## Subdivision PH Comments

**From:** Holly Erdman, Environmental Health Specialist II

**Date:** 02/09/2018

**RE:** Mitchell SP-17-00003 (amended from comments received 01/12/2018)

NANEUM ROAD SHORT PLAT  
 PART OF SECTION 33, T. 18 N., R. 19 E., W.M.  
 KITTITAS COUNTY, WASHINGTON

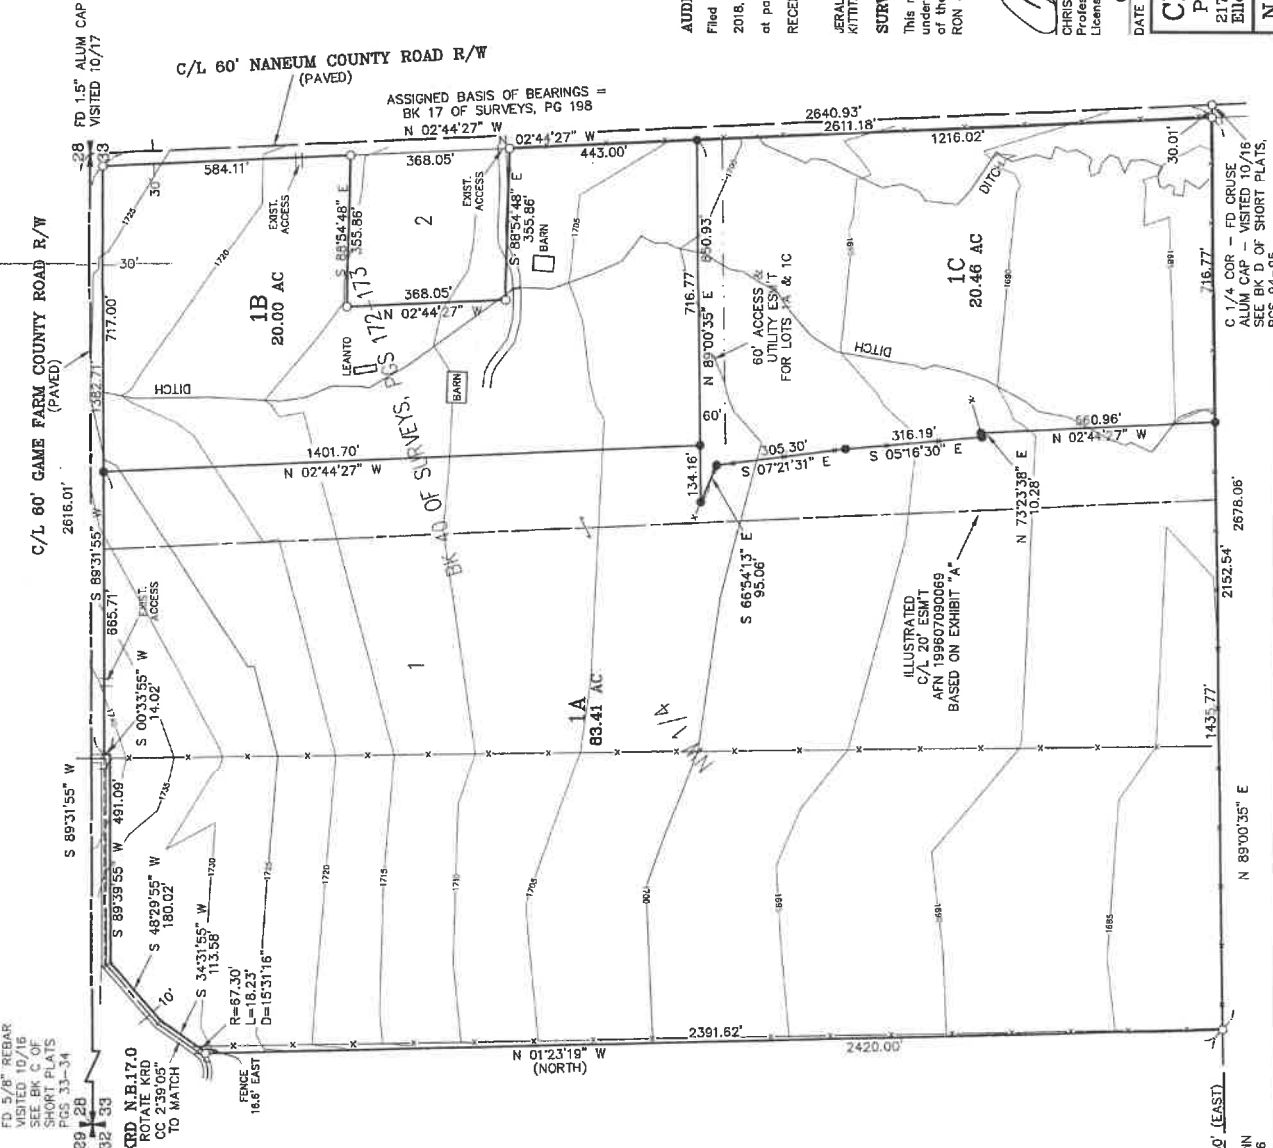
16. Well location. The drawings shall be marked with a "w" indicating location of the well and a broken line showing the one hundred foot radius around such.

All wells must meet the distance requirement of 50 feet from the property line, 50 feet from the septic tank and 100 feet from the drain field as per Kittitas County Critical Areas Ordinance 17A.08.25, and KCC Chapter 13. If existing wells do not meet the setback requirement from property lines, the two adjoining parcels nearest the well must enter into a legal, shared well-users agreement.

**16.12.030 Existing conditions – Unless otherwise indicated, the following shall be shown on the preliminary and final drawings.** (7) Except for administrative segregations, one soil log shall be performed and information recorded for each lot within the proposed subdivision. Soil logs shall be in accordance with WAC 246.272A.

(9) A statement regarding the contemplated sewage disposal, potable water supply, and drainage improvements for the proposed subdivision.
